SUNNICA ENERGY FARM

8.97 Applicant's Response to LPA Deadline 6 Submissions

8.97 Applicant's Response to LPA Deadline 6 Submissions

2.1 Interested party – Cambridgeshire County Council – D5

ACM-60589004-AMR-DR-0039

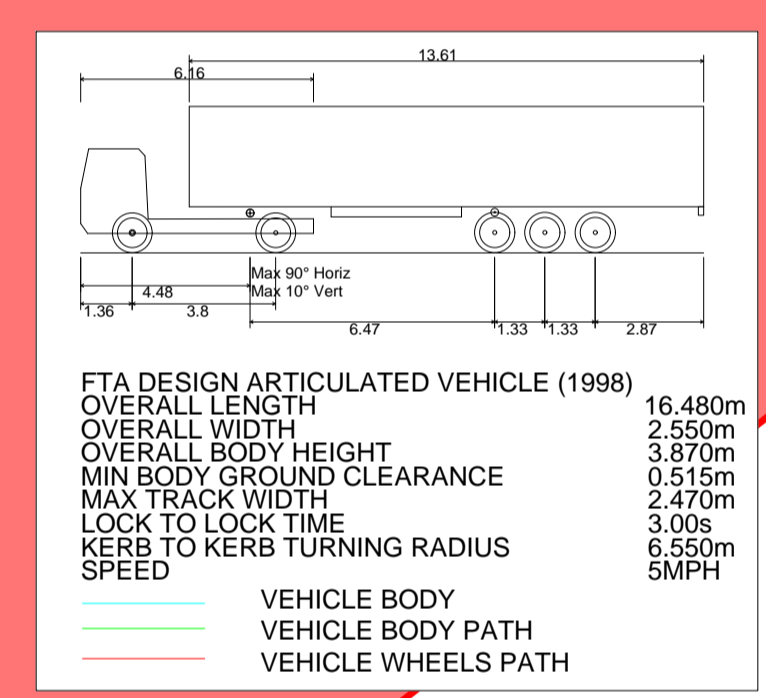
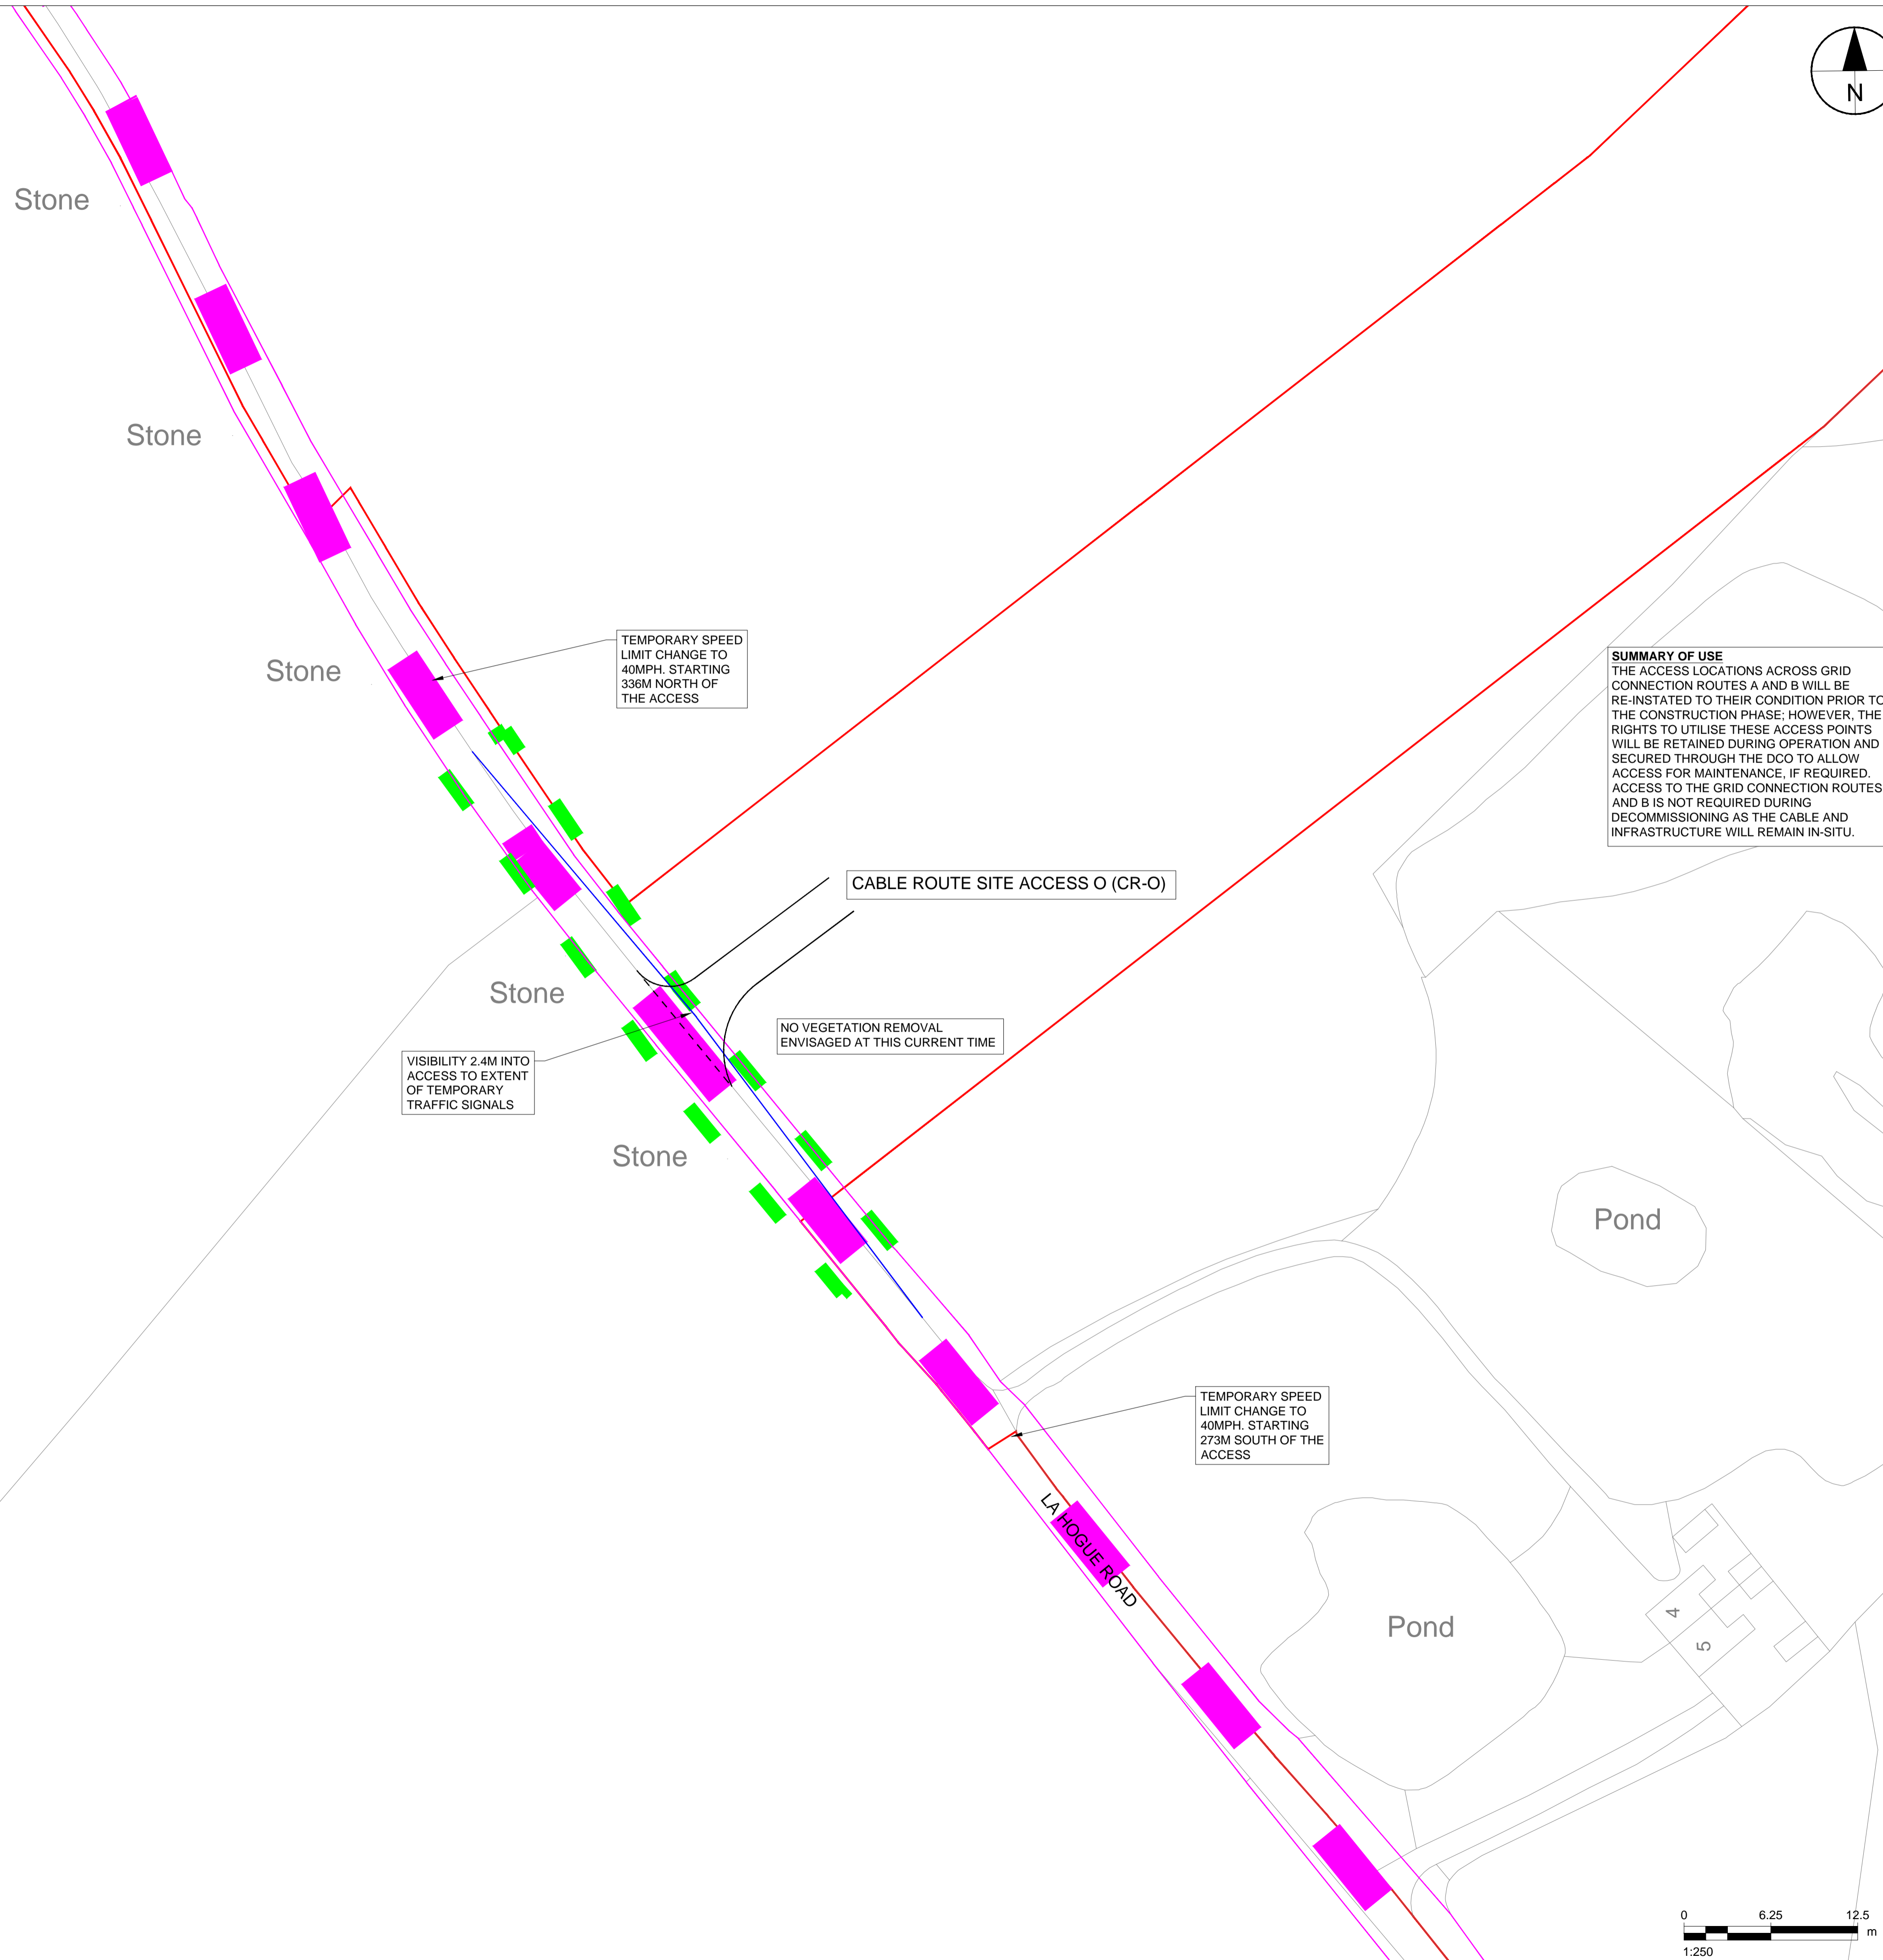
Topic	Deadline and Document Ref	Summary of issue raised	Applicant Response
Plan ACM-60589004-AMR-DR-0039/-0040	Cable Route Access Q. B1085.	<p>The proposal is to utilise an existing field access, with improvements proposed, including 14m radius to the east and 6m radii to the west.</p> <p>The swept path detail shown does not demonstrate the ability for two vehicles to pass, and while movement will be managed by traffic signals during the construction phase, it is unclear how the access will be used during the operational phase, or how such conflict will then be managed. It is therefore unclear whether safe access is provided.</p> <p>No visibility splays have been detailed to demonstrate that visibility appropriate to the speed of the road can be achieved within the DCO or Highway boundary. The highway is bounded by a dense hedgerow to the west and trees to the east, both of which are close the road edge, compounded further by the road to the east bending to the south; It appears unlikely that suitable visibility can be achieved without significant removal of trees/hedge to allow safe uncontrolled access and it is not therefore possible to confirm that safe access can be achieved during the operational phase in the absence of traffic management.</p>	<p>The Site Access Drawings in Annex C of the Framework Construction Traffic Management Plan [REP5-015] will be updated at Deadline 7. Access radii are shown on the plans, which demonstrate that swept path analysis of vehicles can be accommodated.</p> <p>The Applicant's response to EXQ3.9.9 includes a table further demonstrating that there will be no intensification of use of this access in the operational phase. Thus retention of the existing field access in its current form is appropriate for the operational phase. As is set out in response to EXQ3.9.9, there will be no requirement for Sunnica LGVs or HGVs to access the cable route sites, unless a fault is identified remotely. If a fault is identified, the Applicant will be required to agree access arrangements with the LHAs to ensure safe and suitable access. If required, the DCO powers enable the Applicant to re-introduce the Temporary Traffic Management applied during the construction phase. This provides confidence that safe and suitable access can be achieved in any eventuality.</p>
